Your ref:	12B Moreton Place - Windows &...	Please reply to:	Mr Gregor Gault
Our ref:	24/00048/ADFULL	Tel No:	
		Fee Queries:	0207 641 6500;
		Email:	planningreception@westminster.gov.uk;
Mr Gary Kellett Gary Kellett Architects 29 Farwell Road Sidcup DA14 4LQ		Incomplete Applications Town Planning & Building Control City of Westminster PO Box 732 Redhill, RH1 9FL	
		22 January 2024

Address: 12 Moreton Place, London, SW1V 2NP,

Proposal: Details of new windows / rooflights pursuant to Condition 8(i) and 8(iii) of planning permission dated 08 September 2023 (RN: 23/01133/FULL).

A-841-01 02

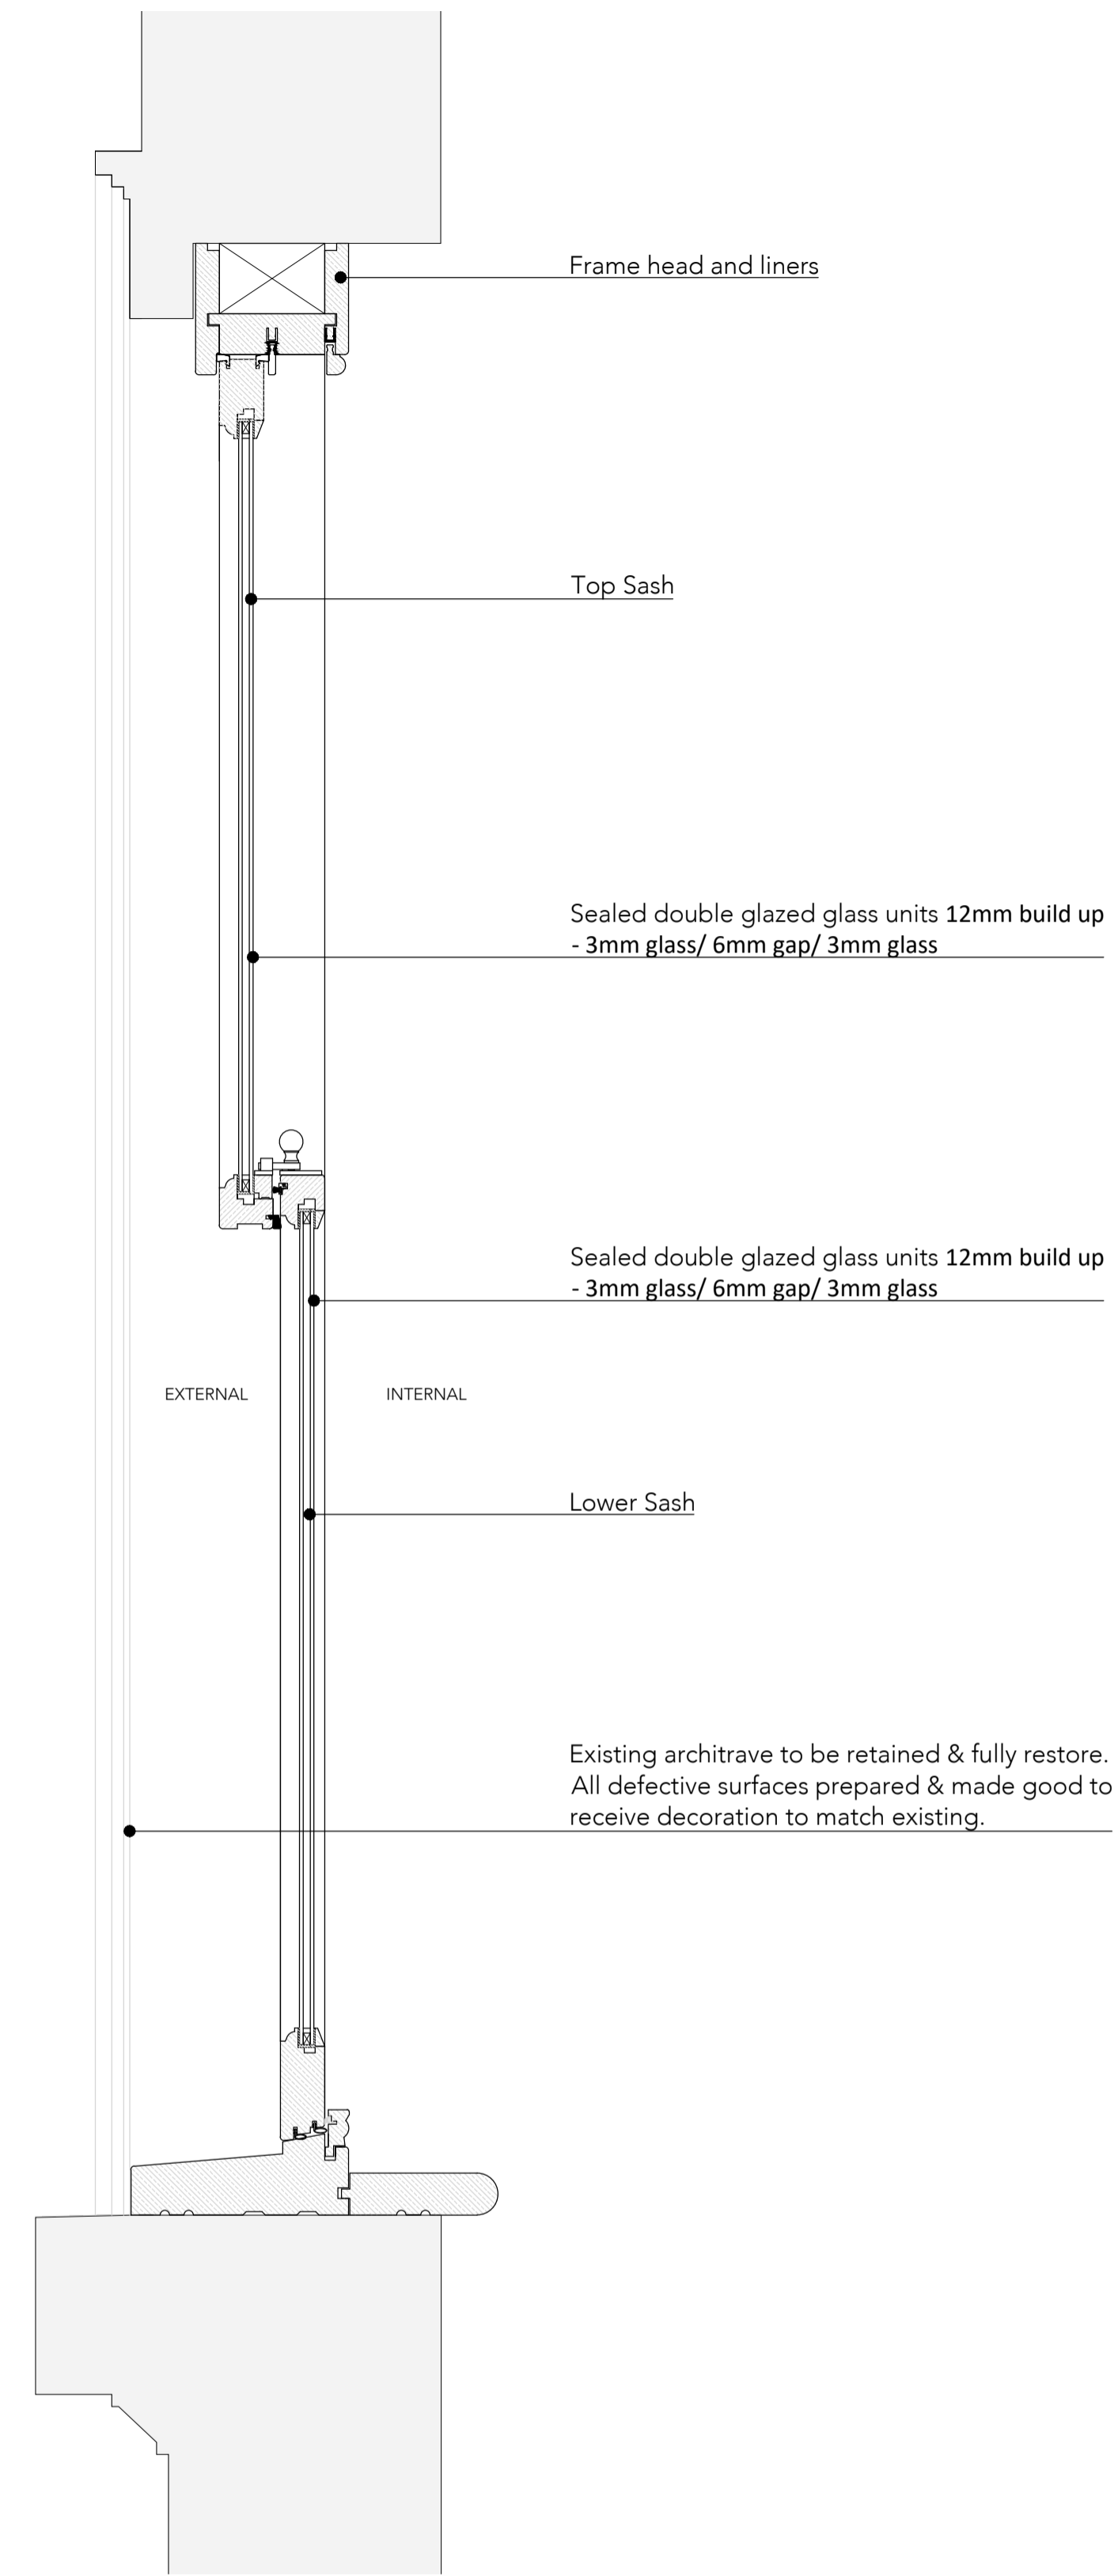
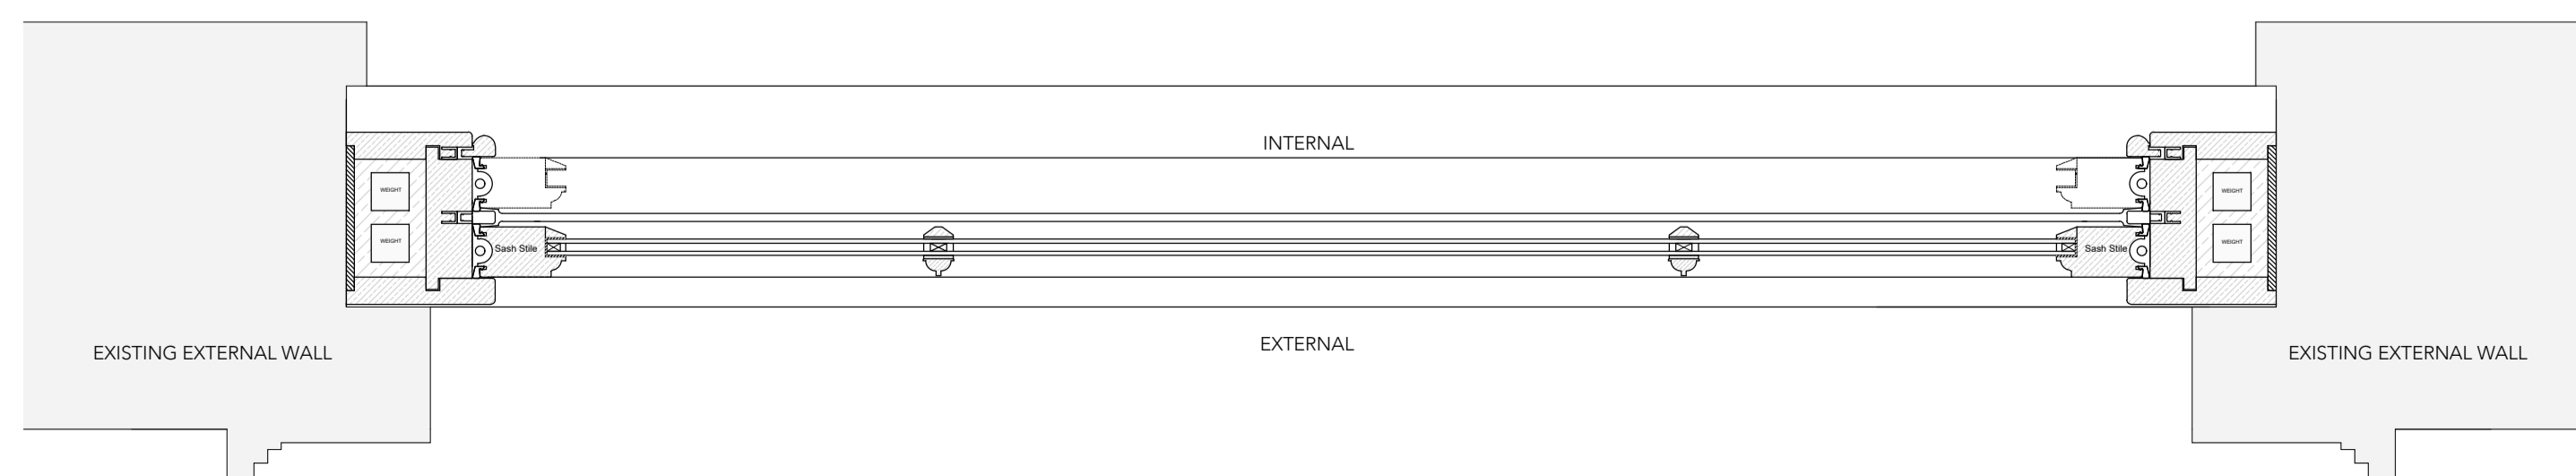
- 1 With regard to part i) please provide typical details for each window type. The replacement of at least 7 different type of windows was approved; however you have submitted only one and you have not identified which of the new windows it represents.
 - 2 With regard to part iii), detailed drawings of the rooflights (and upstands) are required and you have only provided details of the upstand for the rooflight. Please do not include detail of the roof terrace build-up in your drawing as this is not required by the condition.
- 0 *Please collate all requested information in a single submission and send to planningreception@westminster.gov.uk. Sending your documents individually will not speed up the process. Please do not upload to the planning portal as this causes duplication and may delay the processing of your application. Thank you.*
